This email serves to notify you that the City of Albuquerque, Development and Review Department has reviewed the Amended Grading and Drainage Plan (Engineer's Stamp date 5-19-14) for the Property at 9100 Florence Ave. NE.

**SUBJECT: 9100 FLORENCE AVENUE NE (B-20)**  
**Bernalillo County Ref : PWDN 20140036**

**Comment:** COMMENTS FOR PLAN WITH ENGINEER'S SEAL DATED 4/9/2014

9100 FLORENCE AVENUE N.E. AMENDED GRADING AND DRAINAGE PLAN

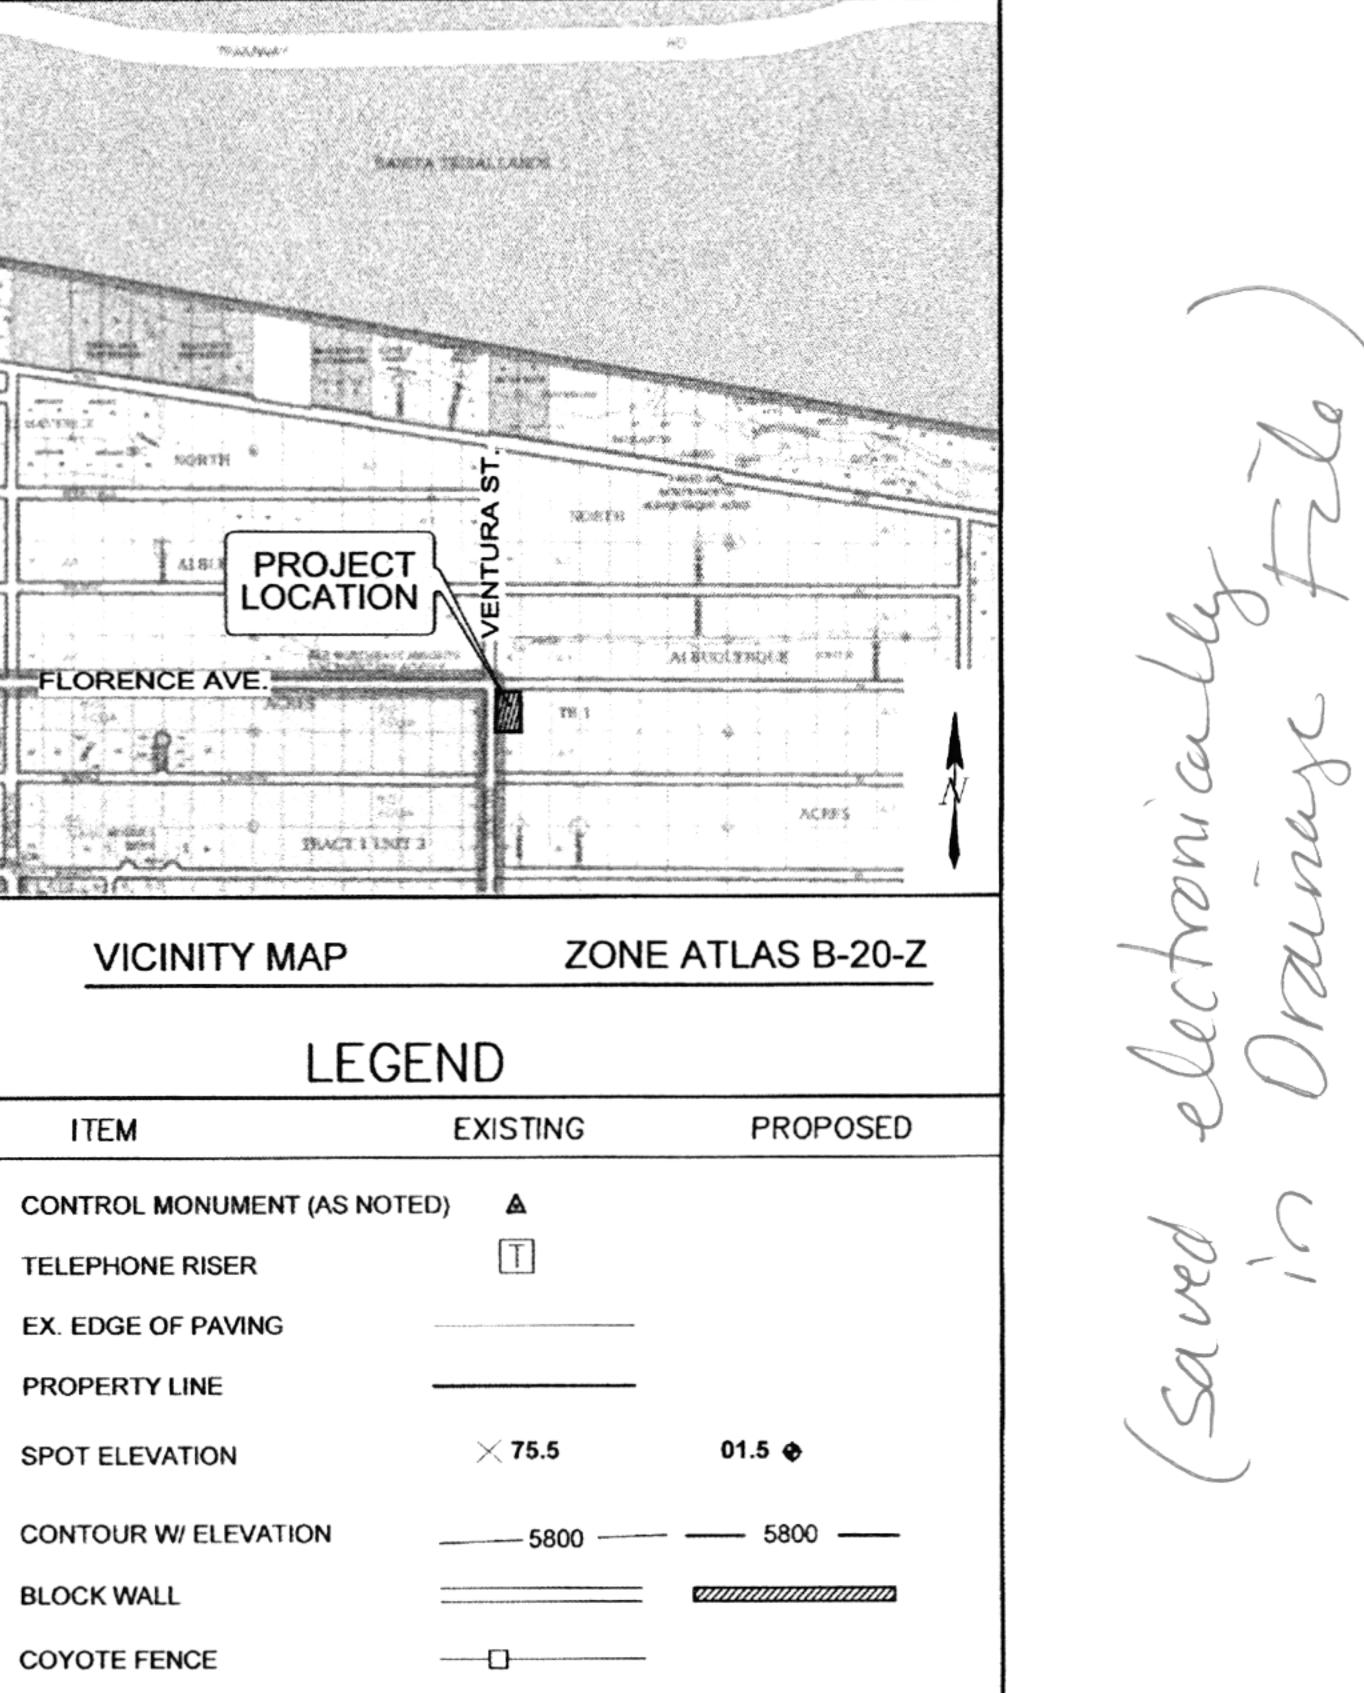
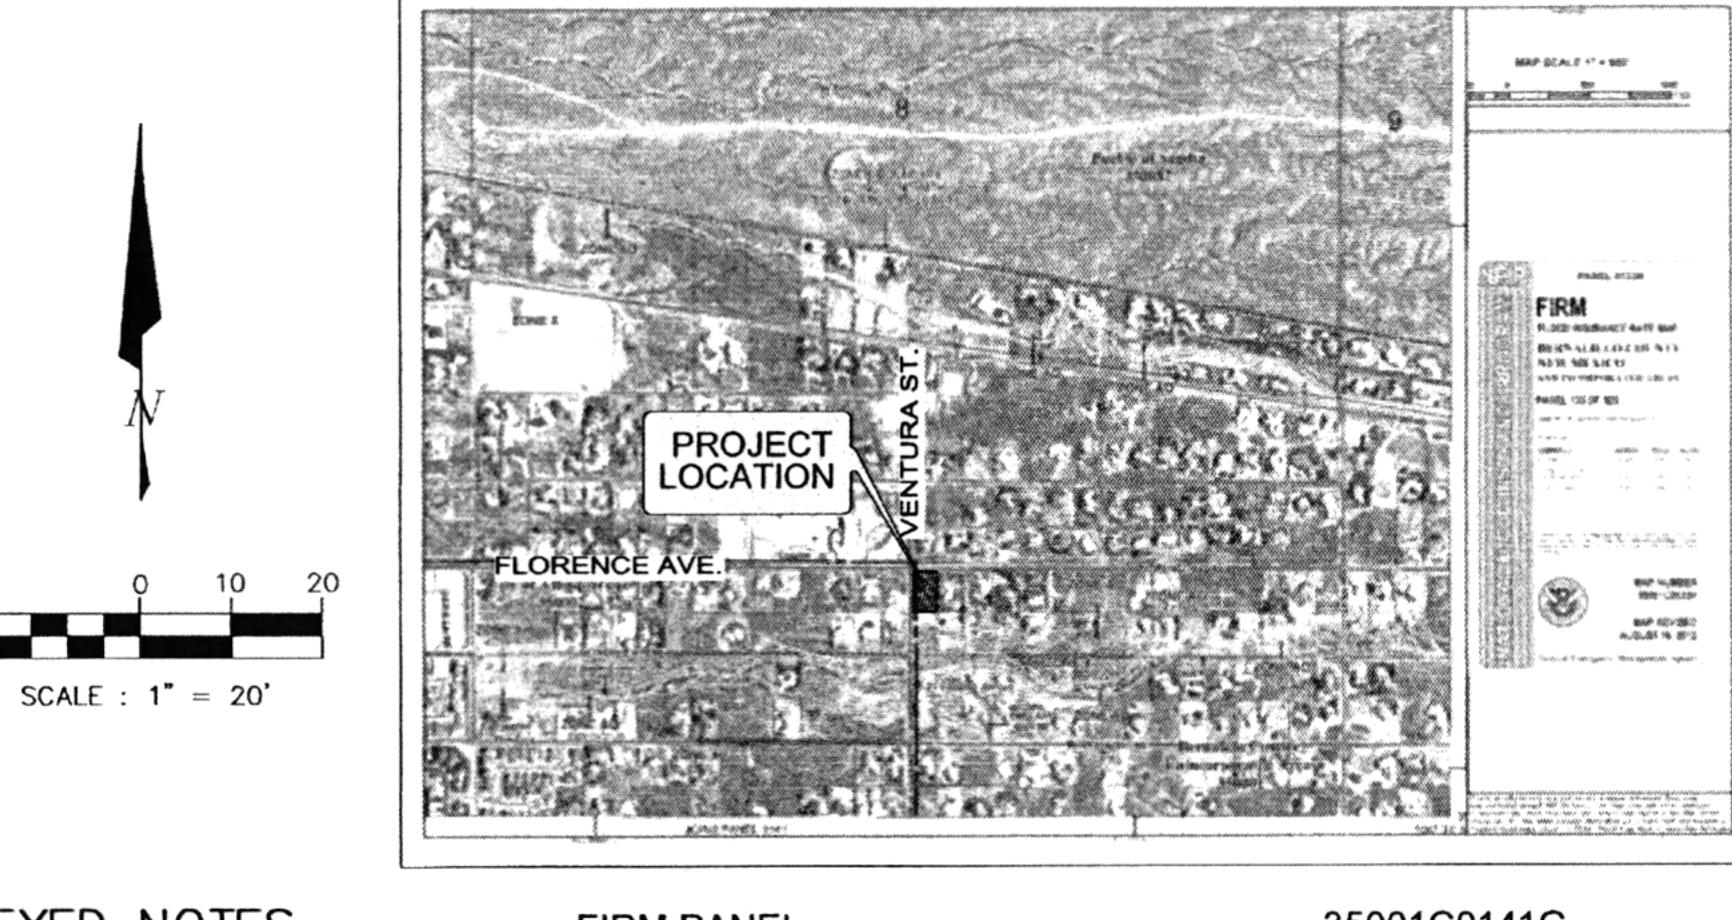
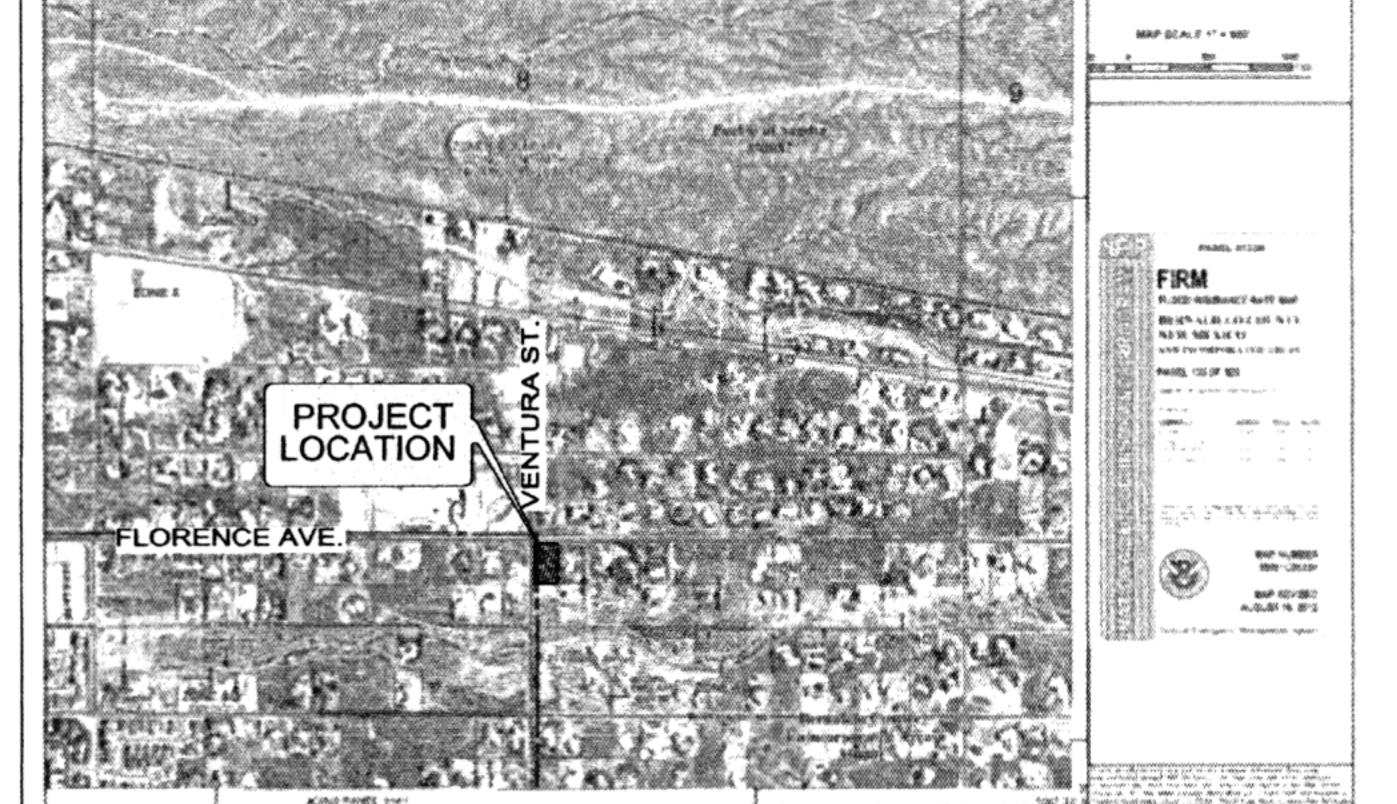
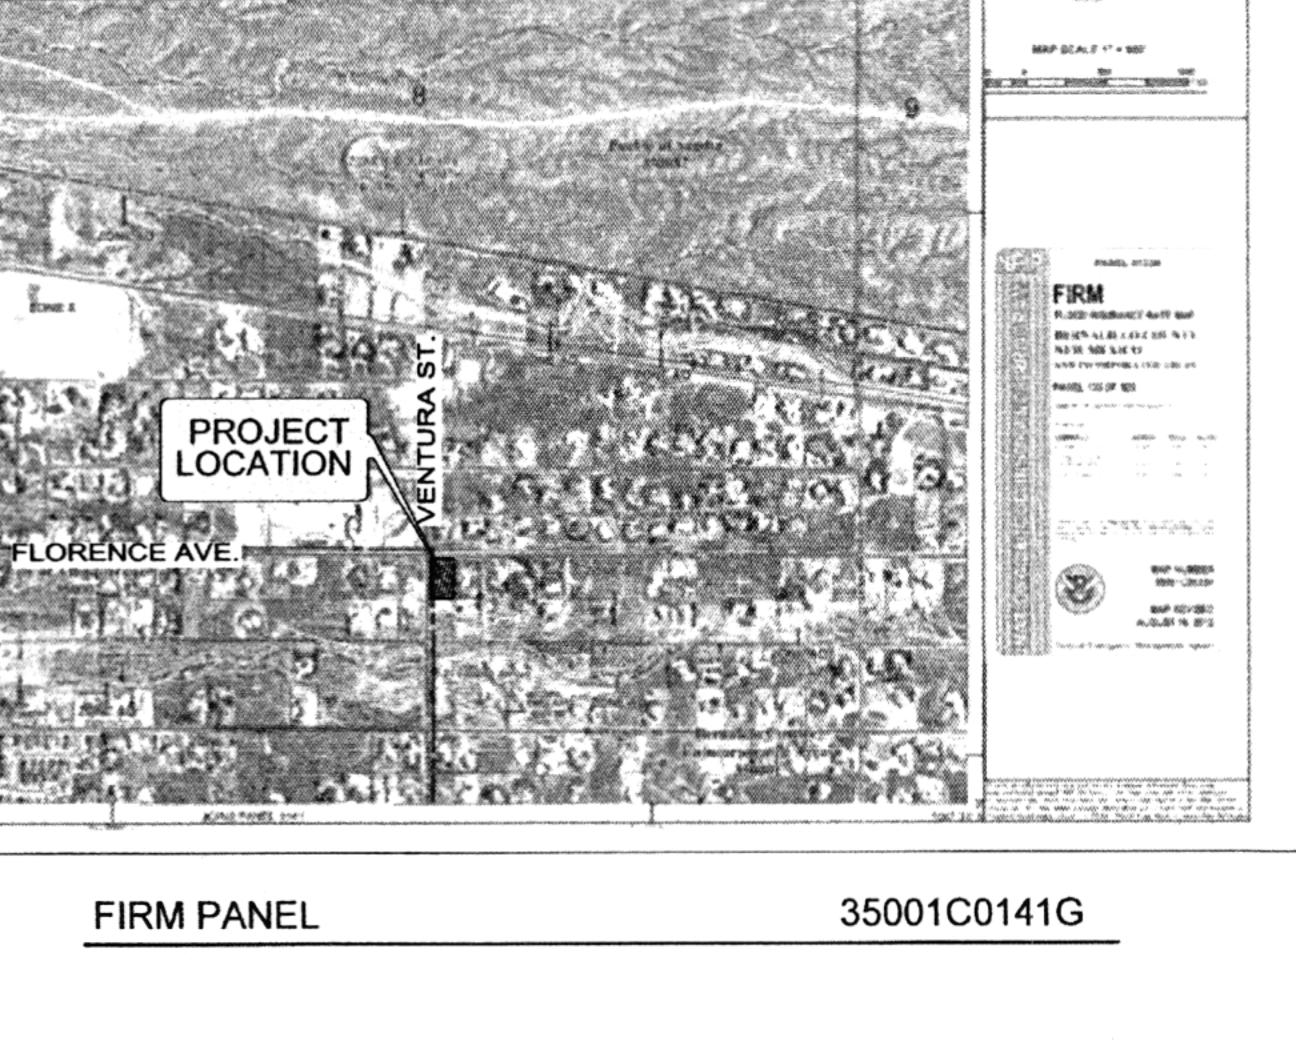
1) Please revise hydrology calculations based on an allowable 43, 20, 20, 17 land treatment balance for the A, B, C, D land treatments respectively.

2) As a portion of the lot drains to the City of Albuquerque right of way. Please provide a letter from the City indicating acceptance of this discharge.

Attached is the updated Grading and Drainage plan for the subject project. At your request, we have subdivided Basin 'B' in to 2 basins. Basin B-1 drains north to Florence. Basin B-2 drains to the ponding area located in the rear yard. Since Basin B-2 is a closed basin, the proposed peak developed flowrate existing the property into City ROW will be less than the existing condition.

The discharge from the Proposed development is less than the existing conditions discharge. Therefore, the City takes no issue and accepts the proposed discharge from this site.
